An
Bord
Pleanála

Inspector's Report

ABP-310090-21

Proposed development will comprise of onshore grid infrastructure including 220kV export cable circuits and fibre optic cables, new 220kV GIS substation at Shelton Abbey and overhead line connection and all associated ancillary works.

Figure 6.26: Proposed Flood Defence Embankment Improvement Works – Indicative Cross Section

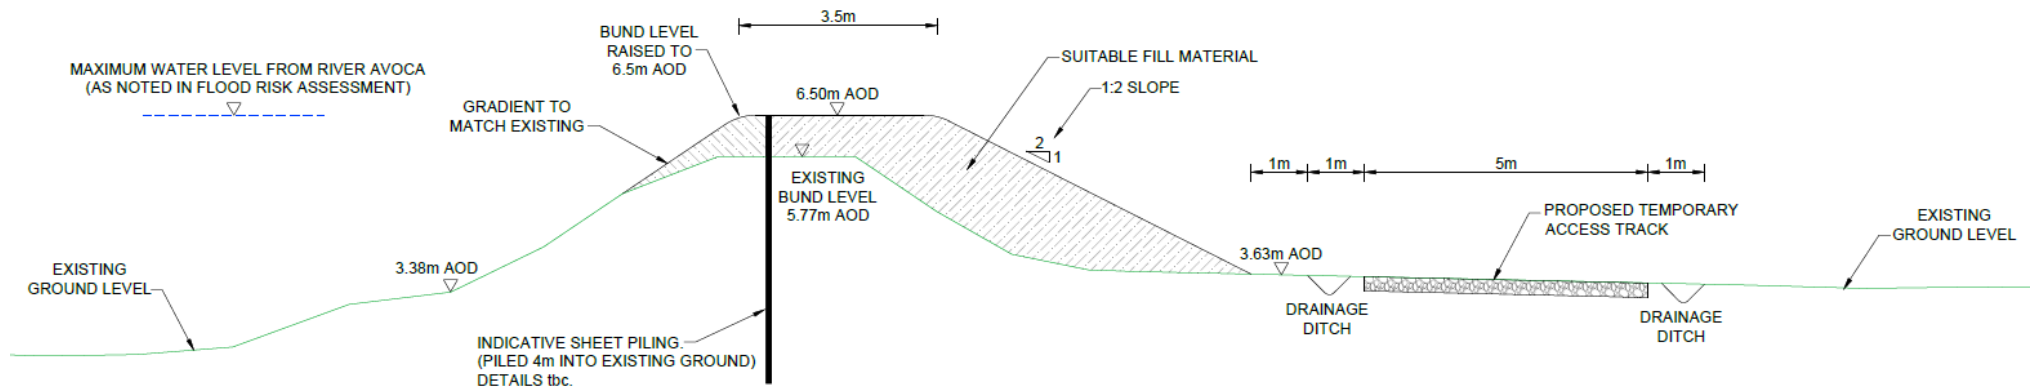
- Flood defence embankment is to be raised by 0.75, design basis for this is unclear.
- Potential for frac out to occur particularly within Templeraíney Stream, the impact to the quality of water within this watercourse has not been assessed nor the downstream consequences.
